CITY OF ALBUQUERQUE

April 26, 2013

RE: **Zia Park Townhouse Apartments – Zia Road NE** File **K22-D022D**
Grading & Drainage Plan for Grading and Building Permit PE Stamp: 4/4/13
Tracts H & I, La Cuesta Subdivision

EXHIBIT "A"
10' PRIVATE DRAINAGE EASEMENT
WITHIN TRACT "J"
LA CUESTA SUBDIVISION
APRIL 2013

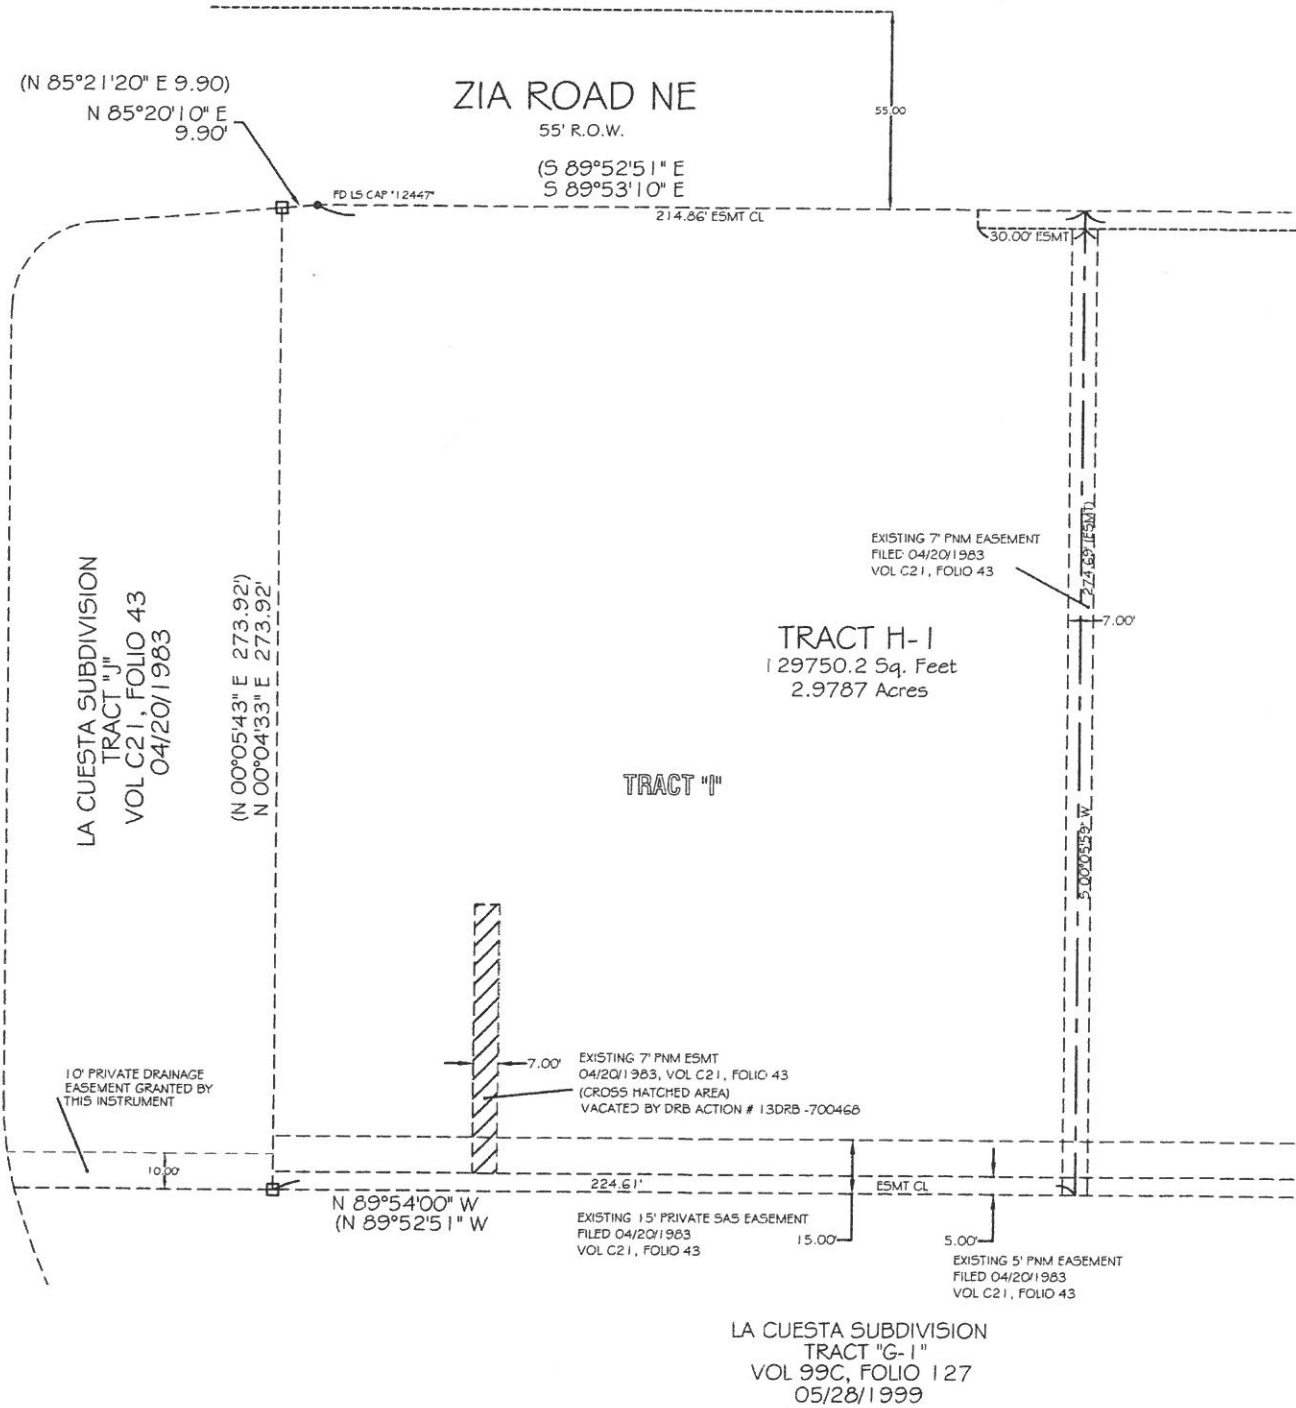
1. An Offsite drainage easement must be confirmed (or obtained) to accommodate site runoff crossing private property. Per your conversations with Curtis Cherne of this office, we understand that you will recommend that your client pursue a Private Drainage Easement to the west, crossing Tract J.

ENGINEER'S SEAL 	ZIA PARK HOMES GRADING AND DRAINAGE PLAN Rio Grande Engineering 1806 CENTRAL AVENUE SUITE 201 ALBUQUERQUE, NM 87106 (505) 872-0999 MAY 2013	DRAWN BY WCMJ DATE 5-07-13 2721-LAYOUT-2-05-13 SHEET # JOB # 2721
---------------------	--	---

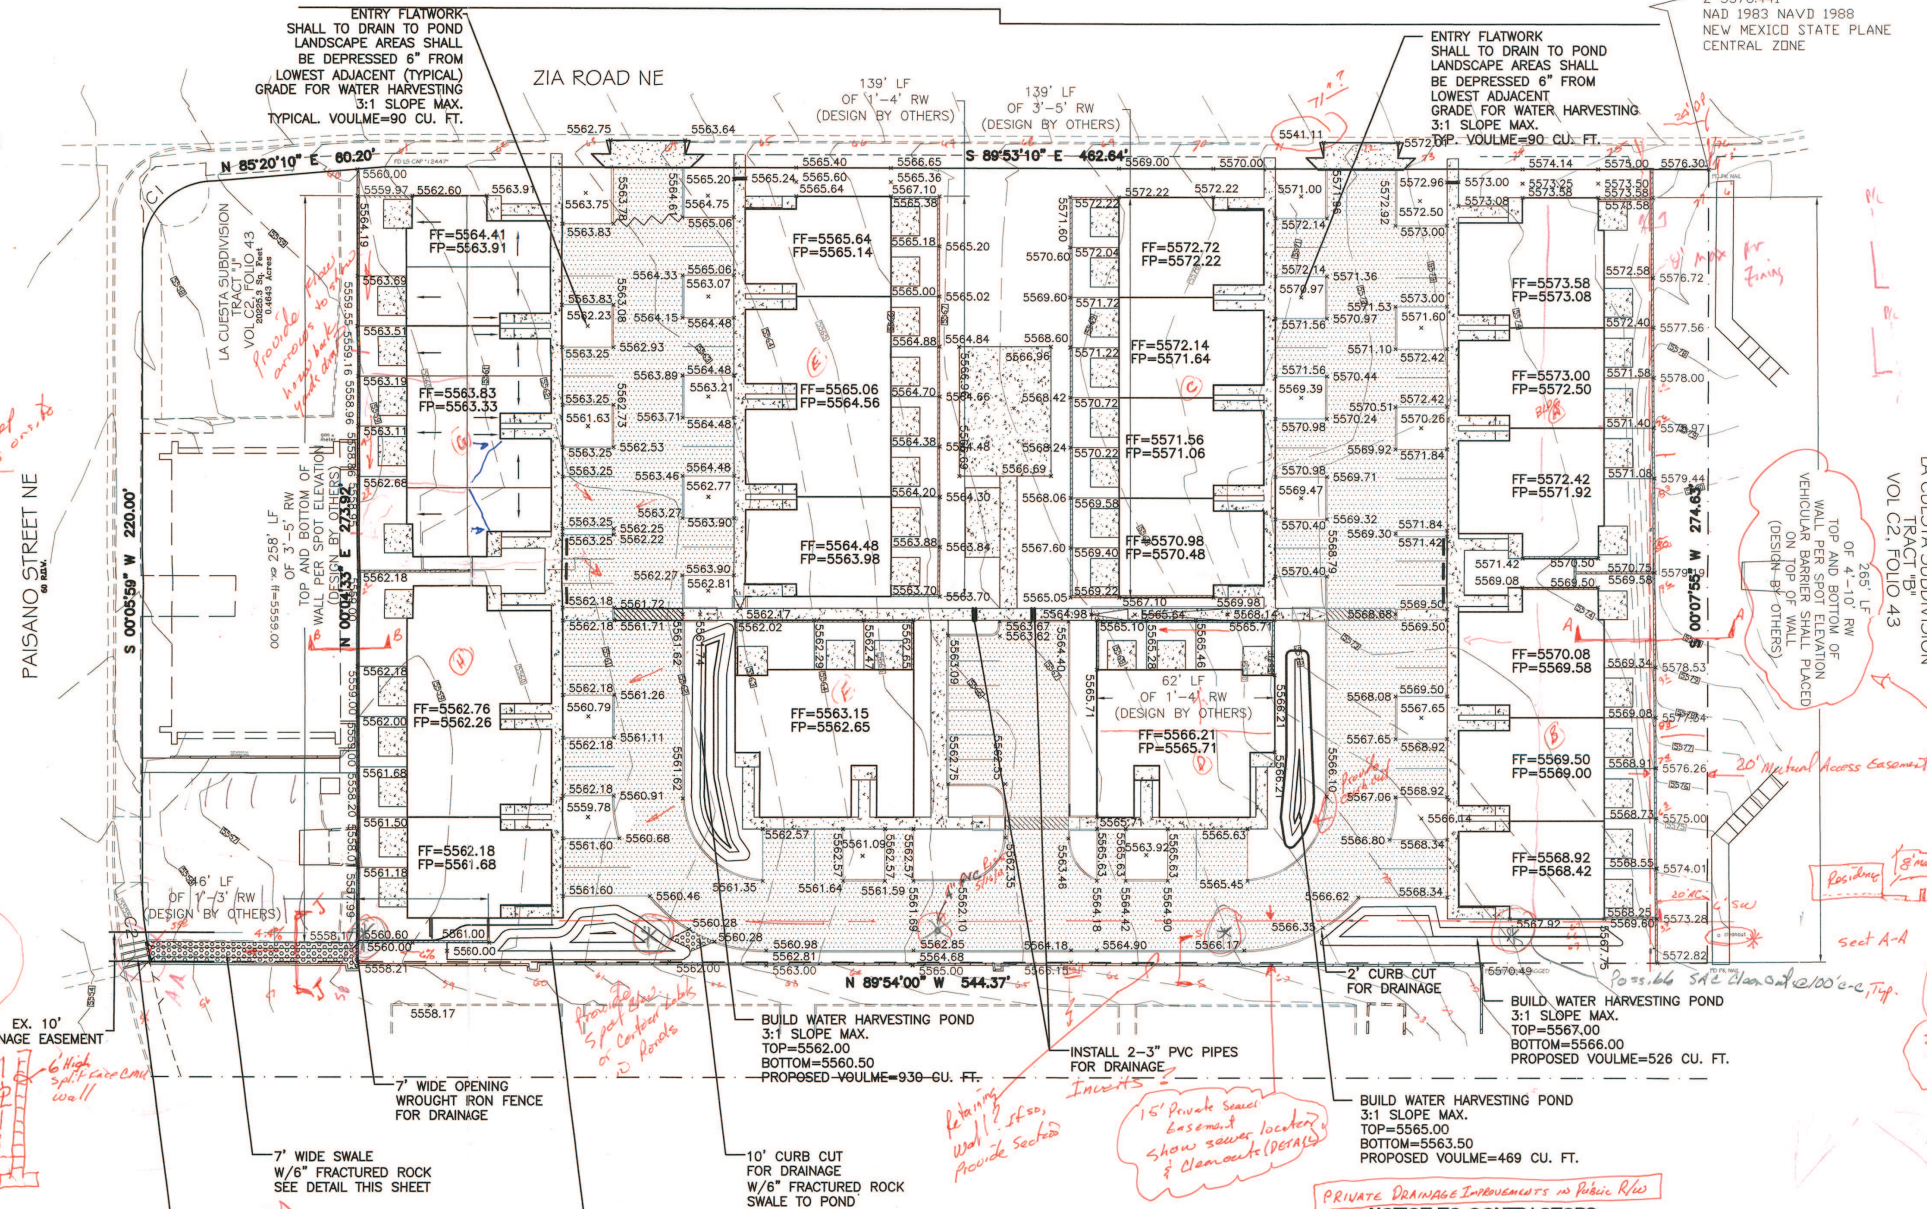
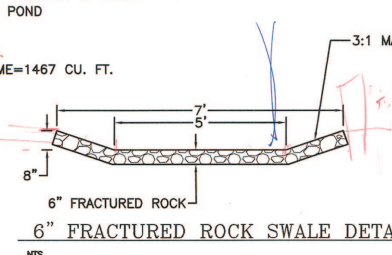
2. As Mr. Cherne has advised in the DRB meeting on 4/24/13, the existing 10' Drainage Easement crossing Tract K is inadequate for the calculated design flow of 76 cfs. If development of the subject site causes developed flows to exceed that level, additional easement width must be acquired from the owners of Tract K.

3. Include all relevant Easement information on the plan.
4. You may opt to grade all or a portion of the site to drain north, onto Zia Road R/W, however this solution must be validated by confirming street capacity on Zia, and in the NM-DOT facilities along the east side of Juan Tabo, at the lower end of Zia.

5. Clearly label (or identify by Legend Key) all proposed structures and surface treatment conditions shown on your plan (e.g.- Pavement, Curbs, Landscape or turf areas, etc.).

6. Water harvesting features must be incorporated into your drainage plan, to intercept the first 0.44 inches of runoff. Show volume calculations in your report.

7. There appear to be several depressed, landscape areas adjacent to the driving/parking lanes. If these are Water Quality/Harvesting areas, label them appropriately. Show with flow arrows, how the water is directed into these areas.

8. The grading plan must show all flow patterns, including the location and direction of roof runoff. Clarify if the backyards are intended to retain storm water runoff.

9. Several retaining walls are called out on the plan as “Design by Others.” At these locations, your plan must call out Top of Wall elevations, and Bottom of Wall, ground elevations on the low side of the wall.

10. There is an existing paved roadway on and along the eastern boundary of the site. Clarify the location of that pavement relative to the tract boundary, and address how the proposed retaining wall (4’ to 10’ high) will interface with that driveway. Building codes may not allow that high of a wall close to the residences, and a vehicle barrier may be necessary at the top of the wall. Also, confirm where existing and proposed runoff will flow in that paved area, behind the retaining wall.

11. If the revised plan includes sidewalk culverts on Paisano or Zia Road, include the appropriate details, notes and inspection signature block for “SO-19” permit, for construction of Private Infrastructure in Public R/W.
